Your Ref: OWPC21916
Our Ref: BR/49/19/OUT 13-02-2019
Please ask for:
Mr S Davis

Outline application with all matters reserved for 22 No. new dwellings consisting of 2 No. 1 bed dwellings, 18 No. 2 bed dwellings & 2 No. 3 bed dwellings.

26 Burnham Avenue Bognor Regis

Thank you for your internet representation made on 31st March 2019 which has been recorded as '**an objection**' with the comments as follows:

Streetscape (Proposed) 1:100
0 2.5 5.0 M

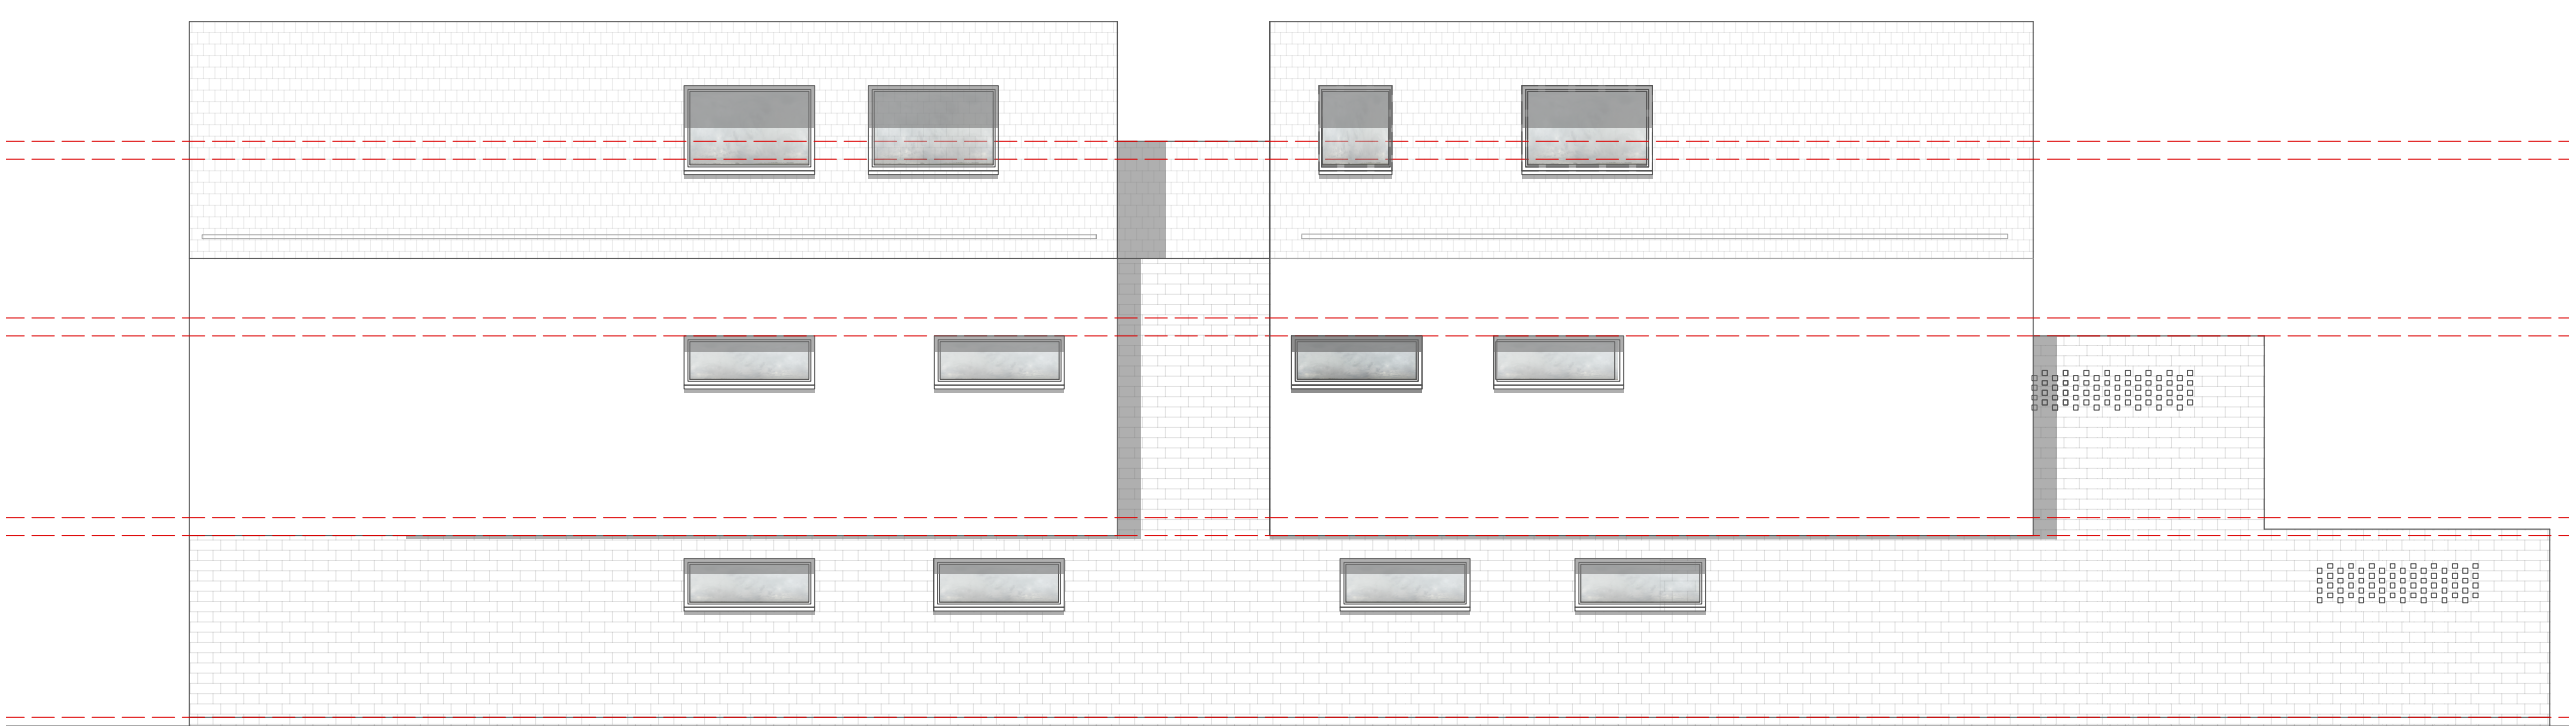
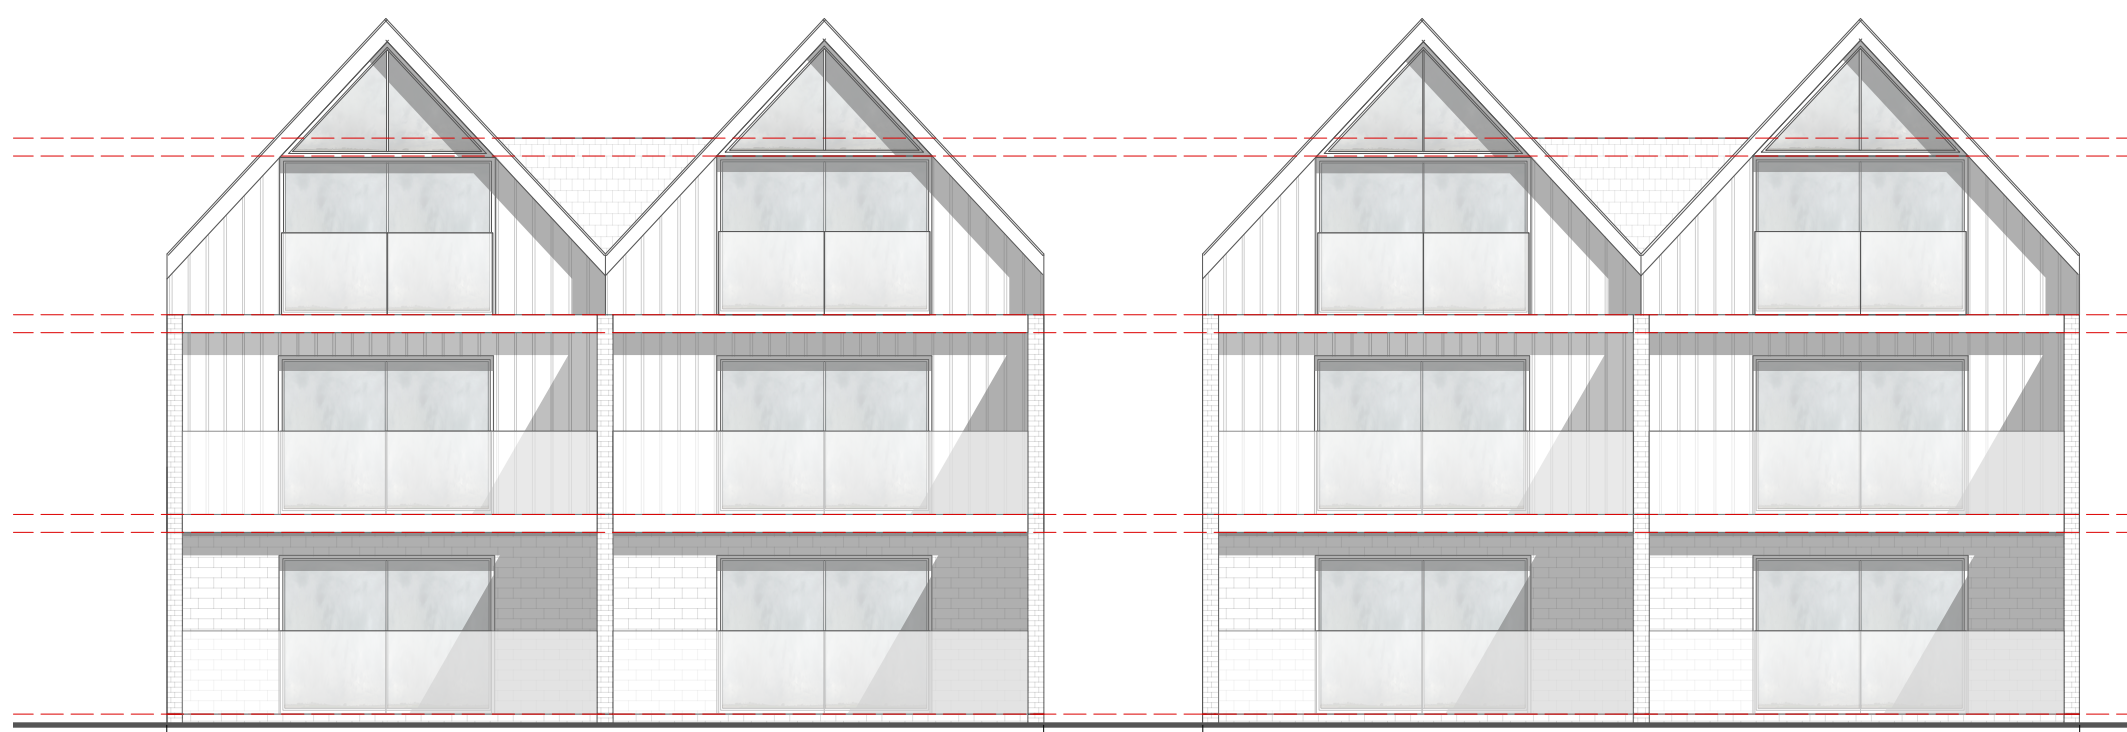
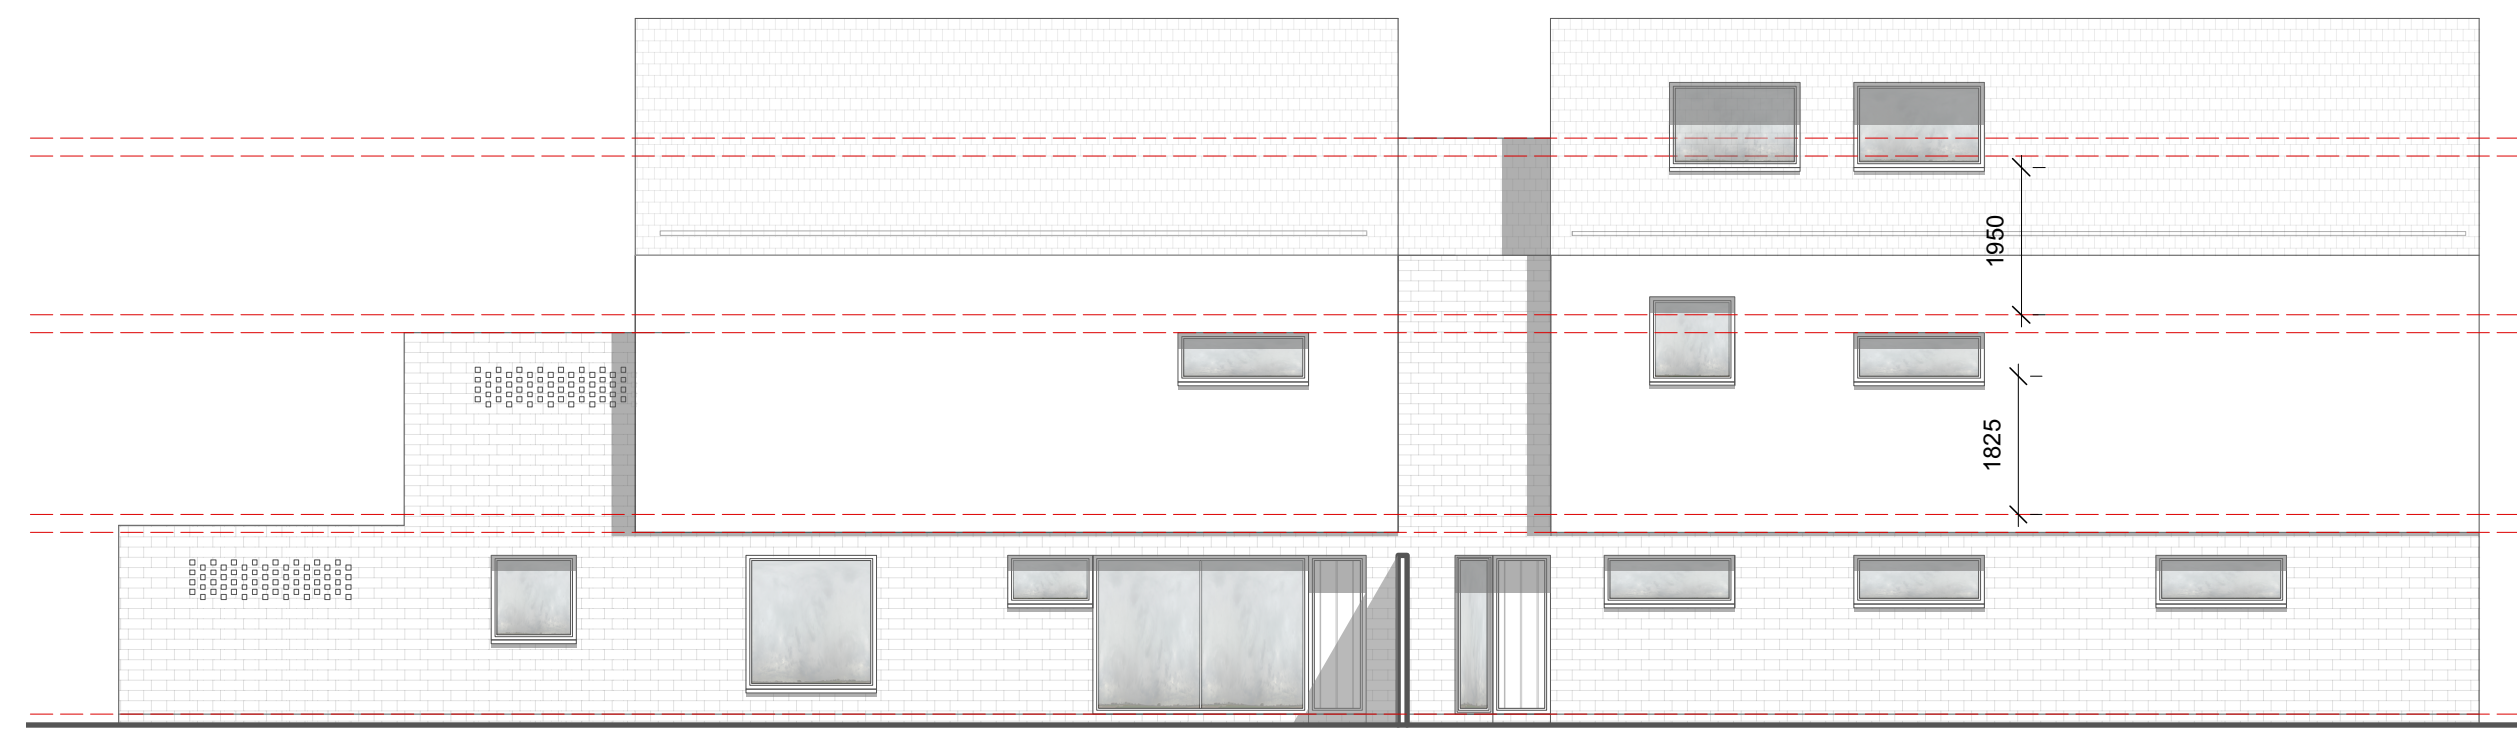
1) The proposal is completely out of character with the neighbourhood. The proposed buildings will dominate the entire street. At the back, they will overlook hitherto secluded properties in Burnham Gardens, creating an invasion of privacy.
